CITY OF ALBUQUERQUE

April 18, 2022

Re: Little Stars Day Care
1500 Coors Blvd NW
Traffic Circulation Layout
Architect's Stamp 04-04-2022 (L11-D045)

TRAFFIC CONTROL LAYOUT - ENLARGED SITE PLAN
1/8" = 1'-0"

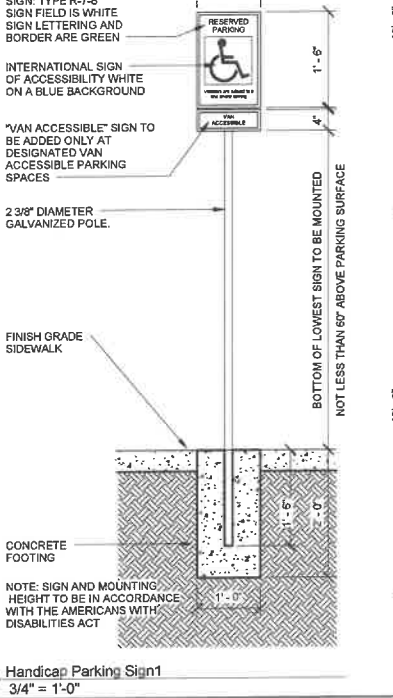
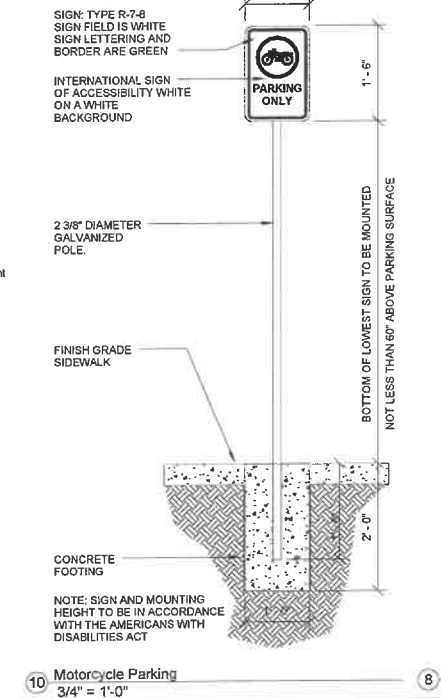
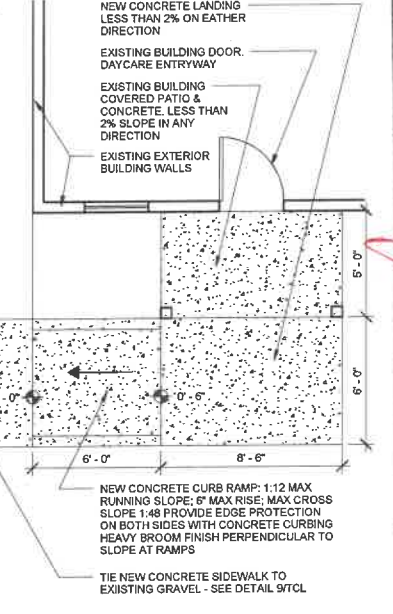
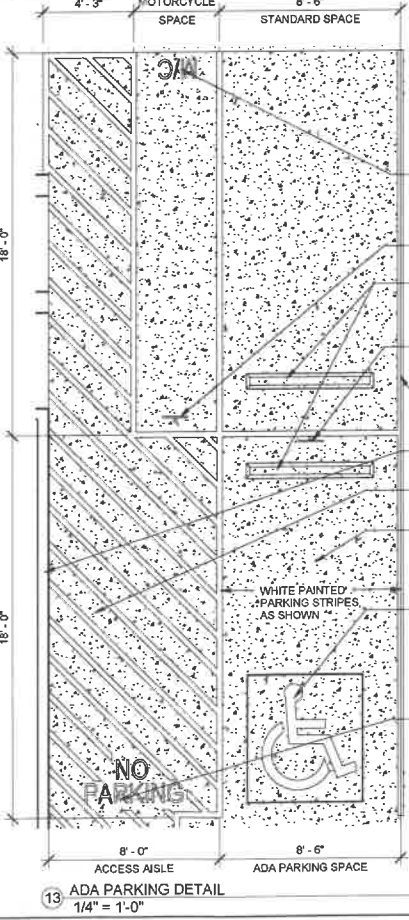
2. Clarify the extents of the current phase. Provide a phasing plan. **Coordinate/discuss with Zoning**.
3. Proposed sidewalk connection (Keyed note 24) from public street and drive aisle are in traffic safety conflict with each other. ADA pedestrian pathway must be raise and not part of the drive aisle width calculations.

4. **Keyed Note 1:** Recycling can must be located in private property.
5. **Keyed 6:** Proposed sidewalk **width needs to be 6 ft min.**
6. **Keyed Note 7:**

- The **width** of Access Point to back lot will need to be 22 ft and not 11'-4 3/8".
 - Access Point/drivepad is not ADA accessible and will need to be. Please provide a current/updated ADA accessible drivepad.

7. **Keyed Note 15:** Provide existing sidewalk width.
8. **Keyed Note 24:** Only 4ft width of sidewalk will be needed (since stall requirement is less than 6 stalls).

20. Per the DPM, a 4 ft. wide ADA accessible pedestrian pathway is required from the public sidewalk to the building entrances (Since your parking stalls are less than 6 stalls). The pathway and the existing drivepad cannot be shared for ADA accessible pedestrian pathway and cannot be used for drive aisle as well .Please clearly address this traffic and ADA safety concern.

21. Per DPM, a 6 ft. wide ADA accessible pedestrian pathway is required from the ADA parking stall access aisles to the building entrances. Please clearly show this pathway and provide details.

22. **ADA accessible pedestrian pathway should not be placed behind parking space or adjacent to a vehicular way. Vehicle and pedestrian/wheel chair conflicts should be avoided as much as possible.**

23. Curbing should be installed to delineate landscape, parking, and pedestrian ways and identify points of access. Please call out detail and location of barrier curb.
